Council Reference: DA09/0701.03 LN35979
Your Reference:

19 June 2019

Development Application DA09/0701.03 - amendment to Development Consent DA09/0701 for a 251 lot residential subdivision (Department of Planning Application MP09_0166 MOD 3) at Lot 1 DP 169490 & Lot 1 DP 175235 & Lot 1 DP 304649 & Lot 1 DP 781687 & Lot 1 DP 781697 & Lot 40 DP 254416 & Lot 43 DP 254416; No. 37 Fraser Drive TERRANORA; Lot 2 DP 778727; Parkes Lane TERRANORA

The Response has been reviewed by Council Officers and the following comments are provided for your consideration during assessment of the application.

SK 3617
REVISION H

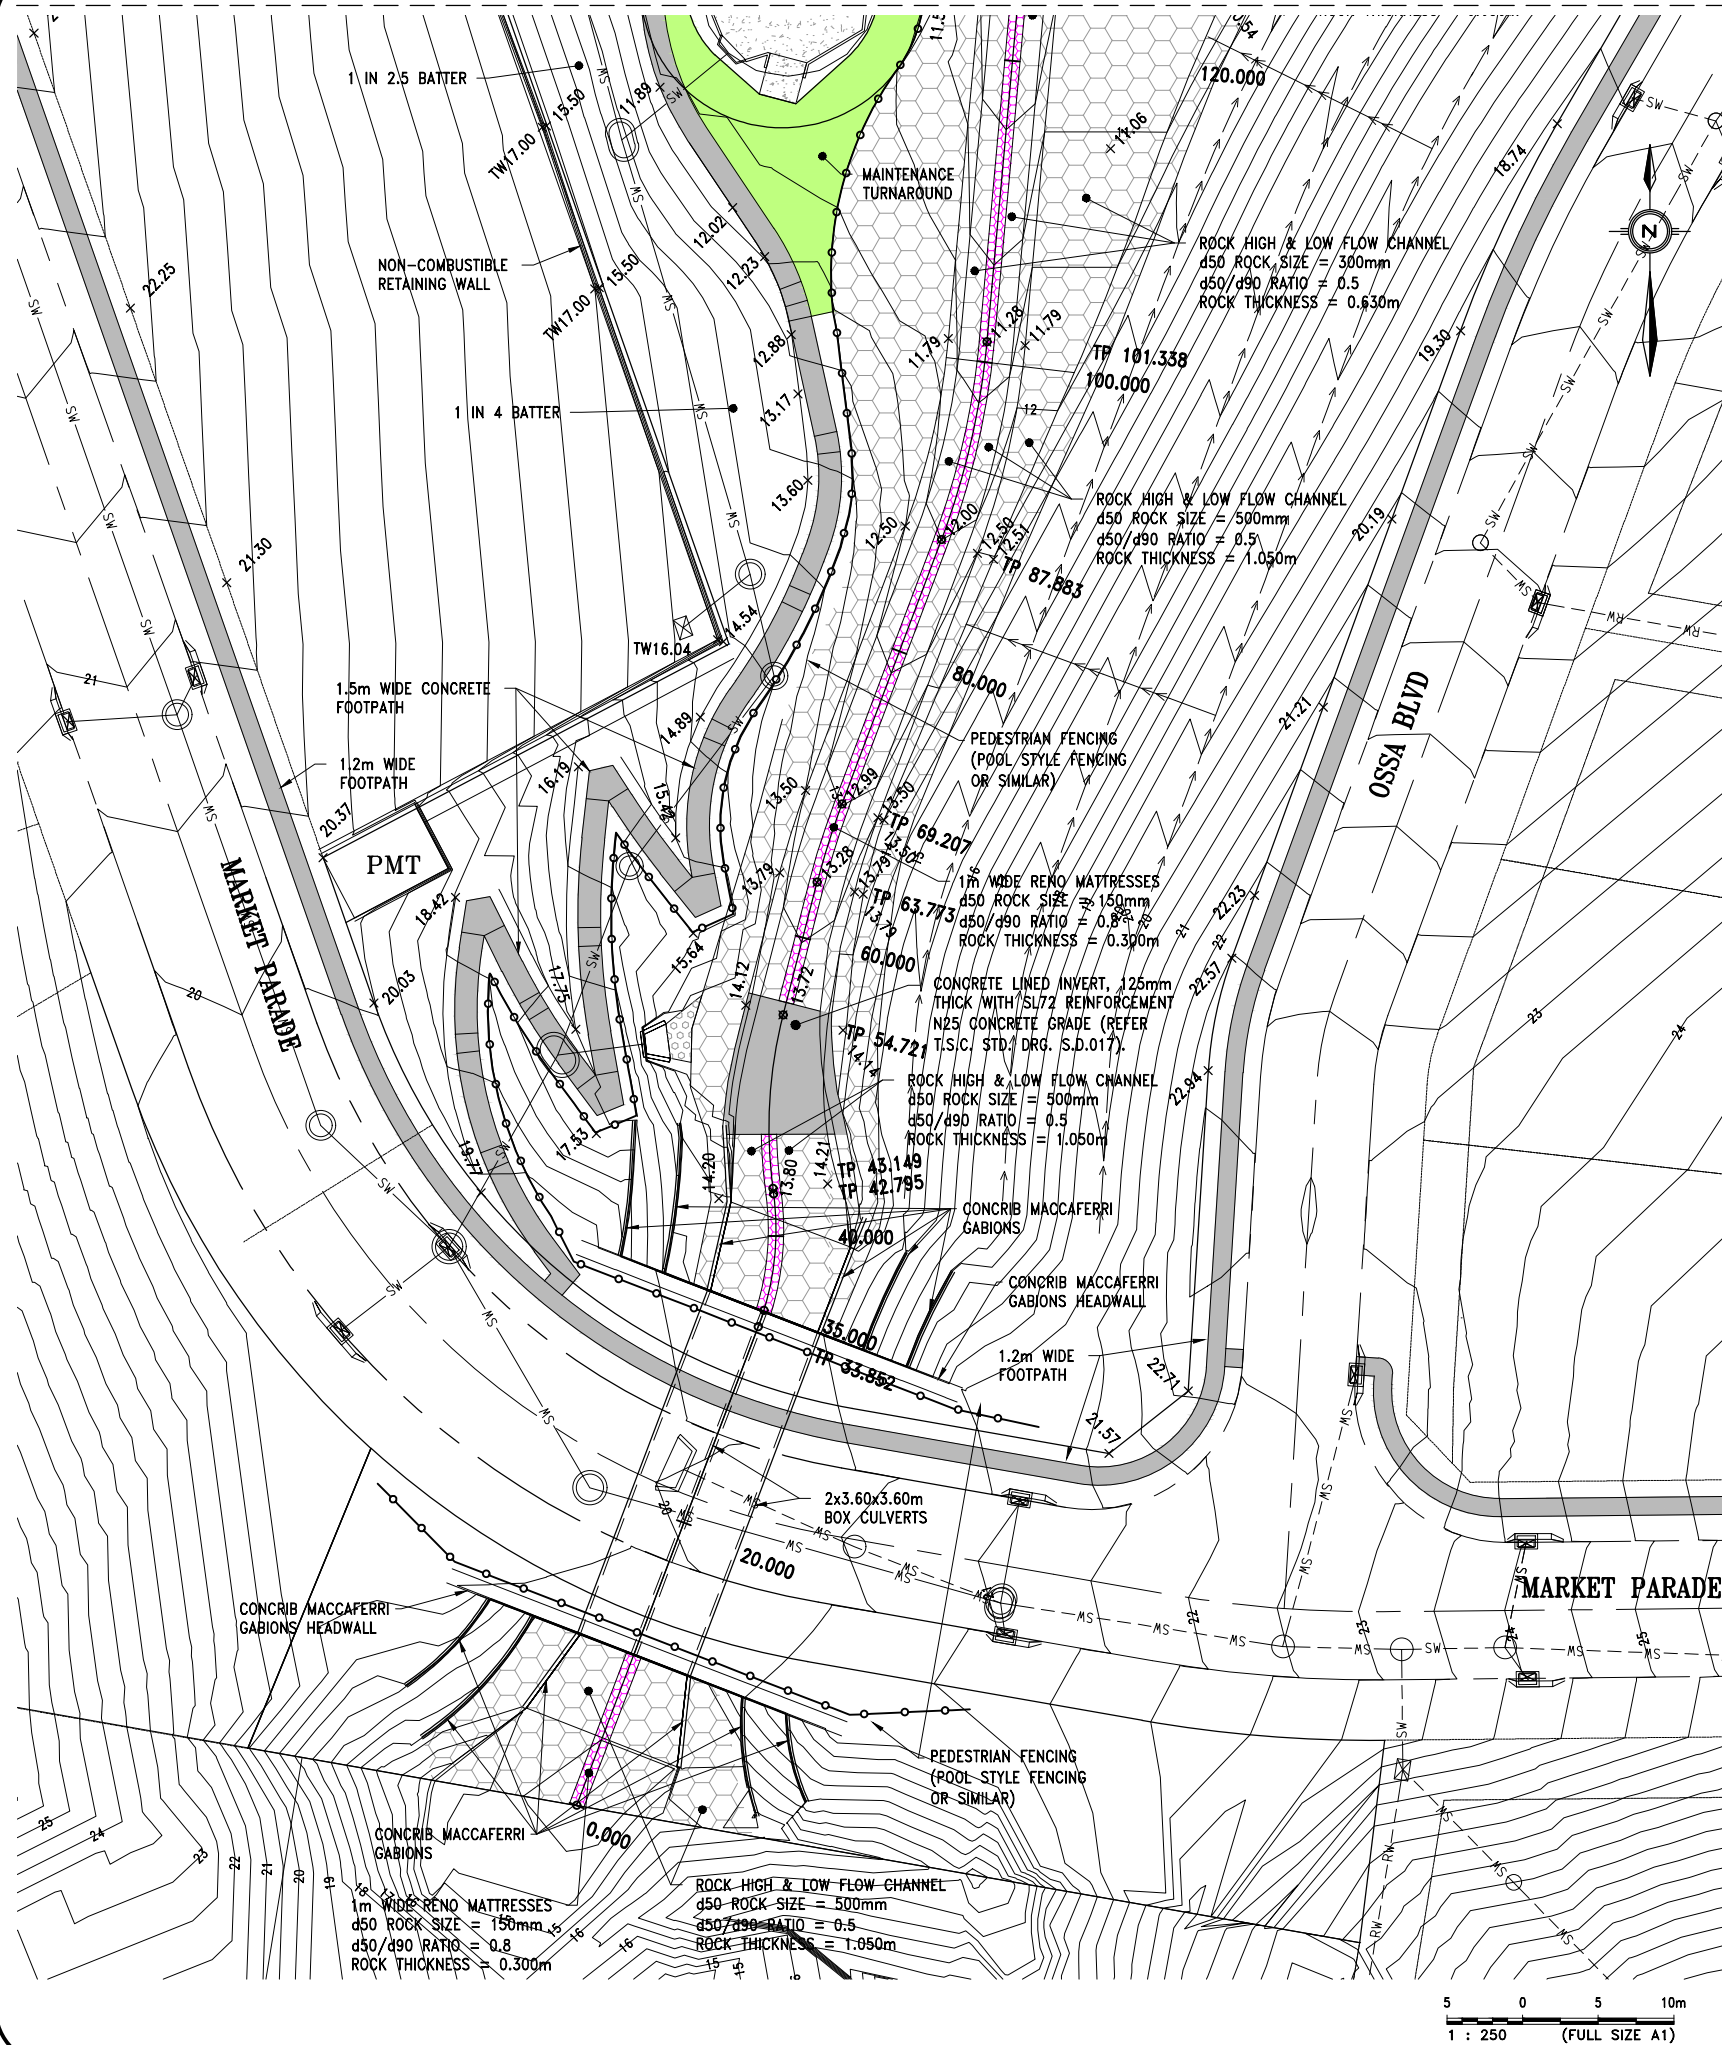
Also, noting that Council now supports the inclusion of SK3617 (per TSC email advice to DPE of 14.2.2019), associated amendment of Conditions A10 and B18 have not been nominated – although agreed to. This is addressed hereunder.

Condition A10 - Limits of Approval: due to the accepted inclusion of SK3617, this Condition also requires amendment as follows:

This approval also does not approve the construction of the proposed retaining walls proposed to create terraced lots in the eastern portion of the site bounded by Proposed Road No 8 to the north, Road 5 to the east, Road 1 and a small section of Road 2 in the south and Road 8 to the west, ~~including any inter-allotment retaining walls to create terraced lots~~, as outlined on SK3617 'Retaining Wall Layout Plan' Revision H prepared by Bradlees Civil Consulting dated 26 May 2019.

Condition B18 - Retaining Walls: due to the accepted inclusion of SK3617, this Condition also requires amendment as follows:

Subject to other conditions of this approval, all retaining walls and batters shall be designed in accordance with Tweed Shire Council's Development Design Specification D6 - Site Regrading. Permissible retaining wall and batter heights are specified in Table D6.1. Boundary retaining walls and batters shall be constructed with a minimum boundary setback of 0.9m in accordance with clause D6.05.6(c) of Development Design Specification D6 - Site Regrading.

The only locations where a setback variation is permitted are Lot 701 and the road frontage boundaries of Lots 812, 918 and 1001.
